Recommendation Report for Planning Permission for Works or Extension to a Dwelling

REF NO: FG/22/25/HH

LOCATION: 12 Beehive Lane
Ferring
BN12 5NN

PROPOSAL: Replacement garage and first floor balcony.

Drawing—Proposed Plans

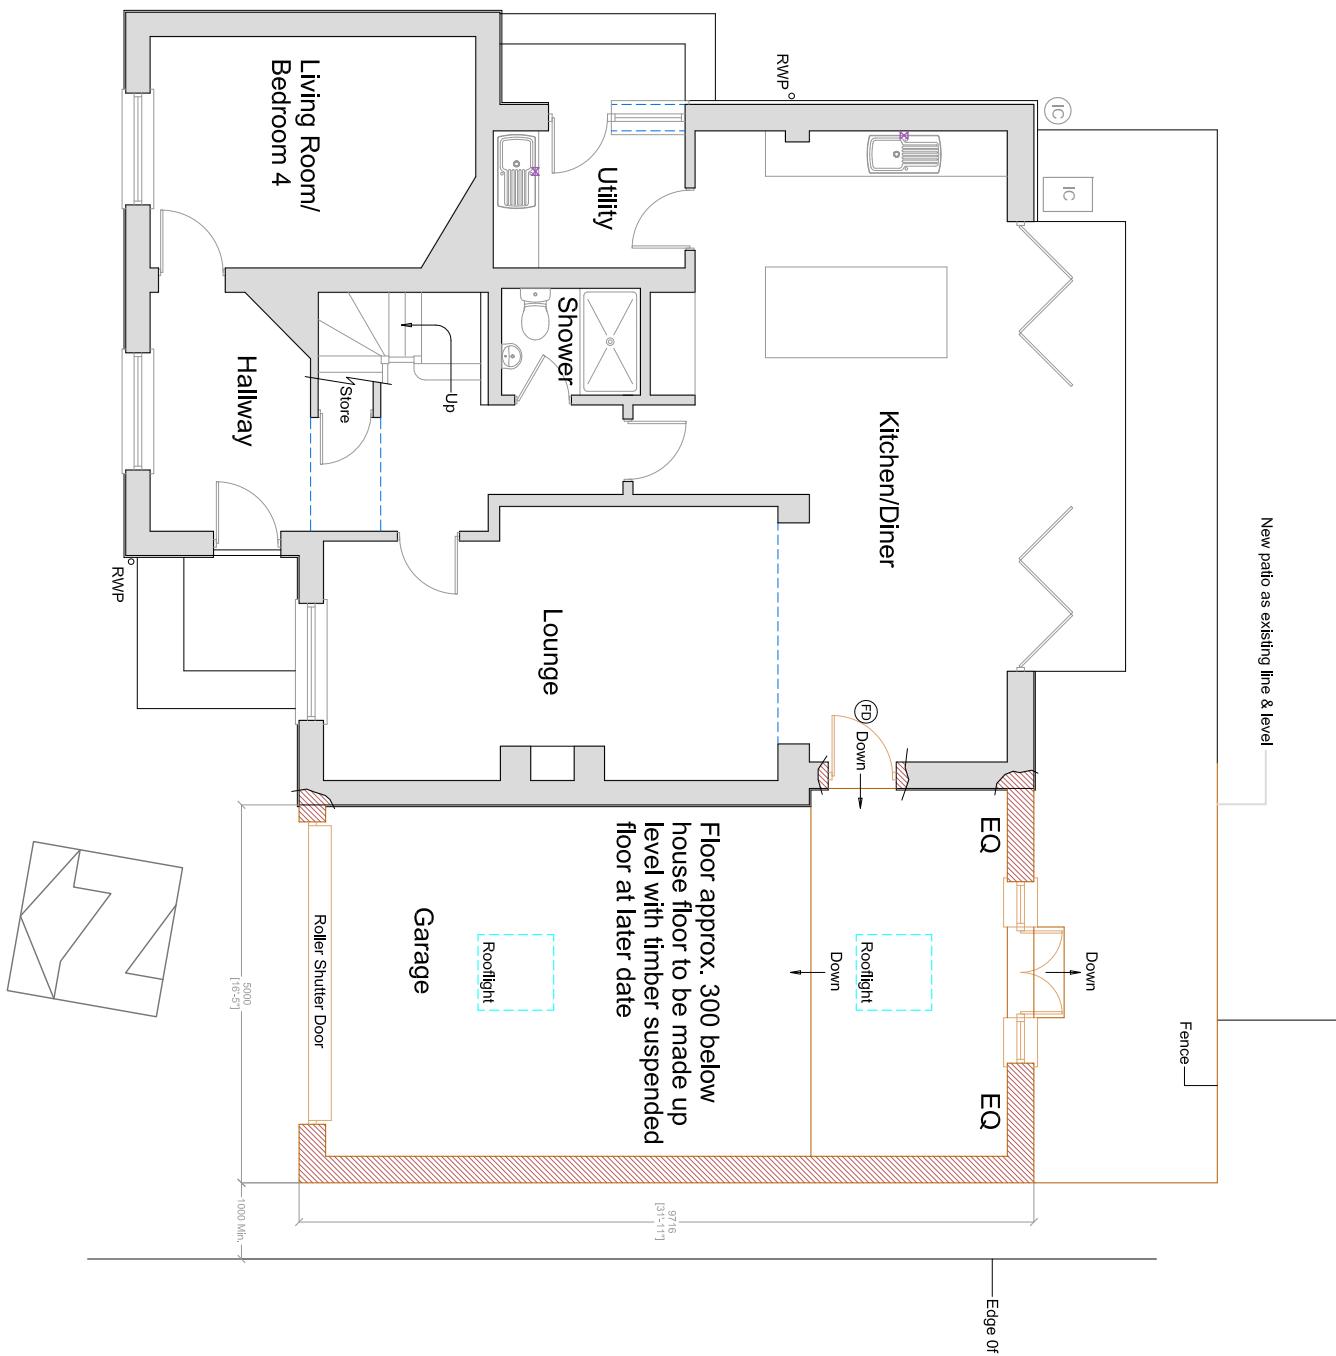
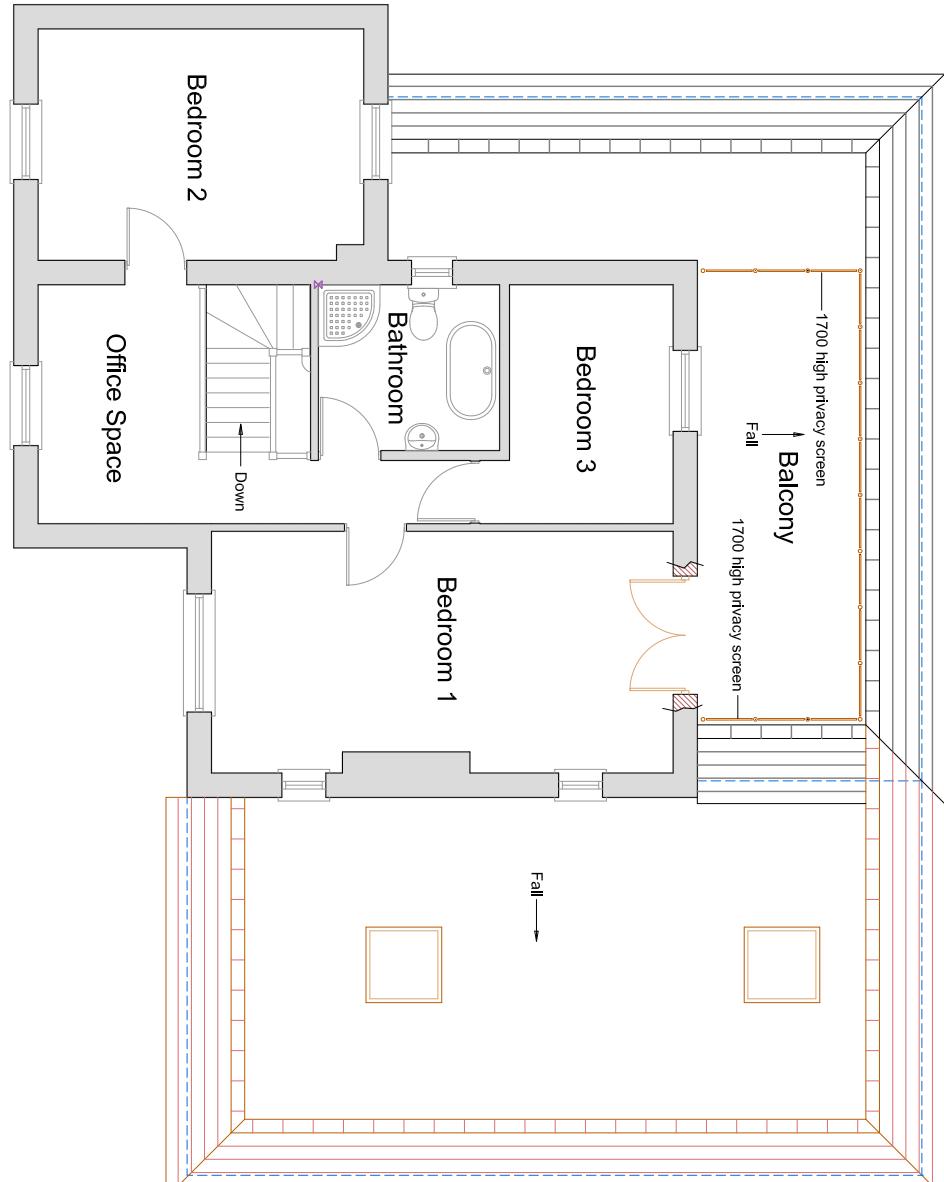
The balcony will be to the rear of the property, above the existing rear extension. The depth of the property's rear garden is approx. 15.8m, beyond this directly to the south area the side elevations and frontages of property's along Chalet Road. Any views which may be gained of these properties from the proposed balcony will not be unduly harmful. From the east of the balcony, views may be gained into the rear gardens of neighbouring properties to the east and south, and views into the amenity space of properties opposite may be gained from the west. In order to mitigate these harmful overlooking impacts, screening has been proposed to the sides of the balcony, and a condition has been added to the permission requiring the screening to be maintained at a height of 1.7m in perpetuity.

Following amendments to the proposed plans and addition of conditions, the overlooking impacts of the proposal have been mitigated sufficiently and the proposals will not harm neighbouring residential amenity in accordance with Arun Local Plan policies D DM1 and D DM4.

4 The balcony hereby approved shall have fully obscured screening to a minimum height of 1.7m to the full depth of the balcony. The screening shall be provided to both eastern and western elevations prior to its first use. This arrangement shall be permanently retained thereafter.

Drawing – Proposed Elevations & Section

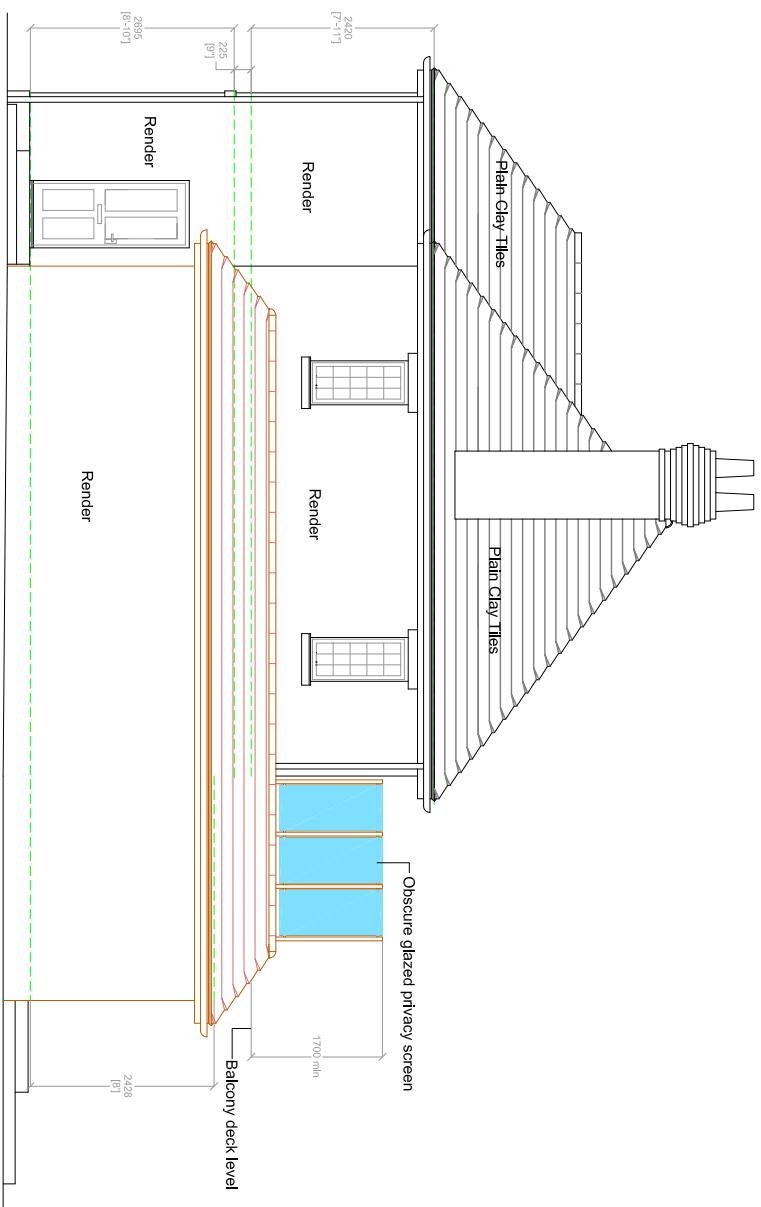
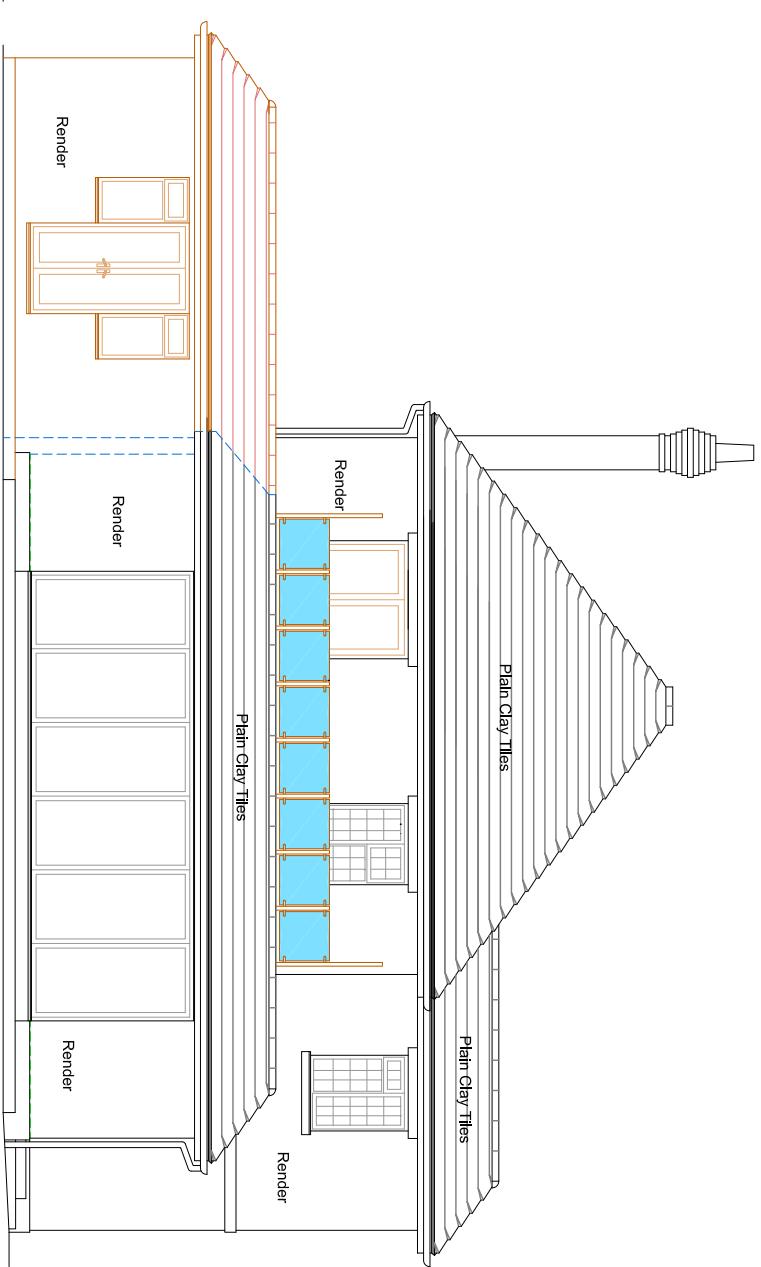
The proposed balcony will involve the installation of a glazed balustrade above the existing single storey rear extension. The visual impact of this will be minimal and will not harm the character or visual amenity of the area.
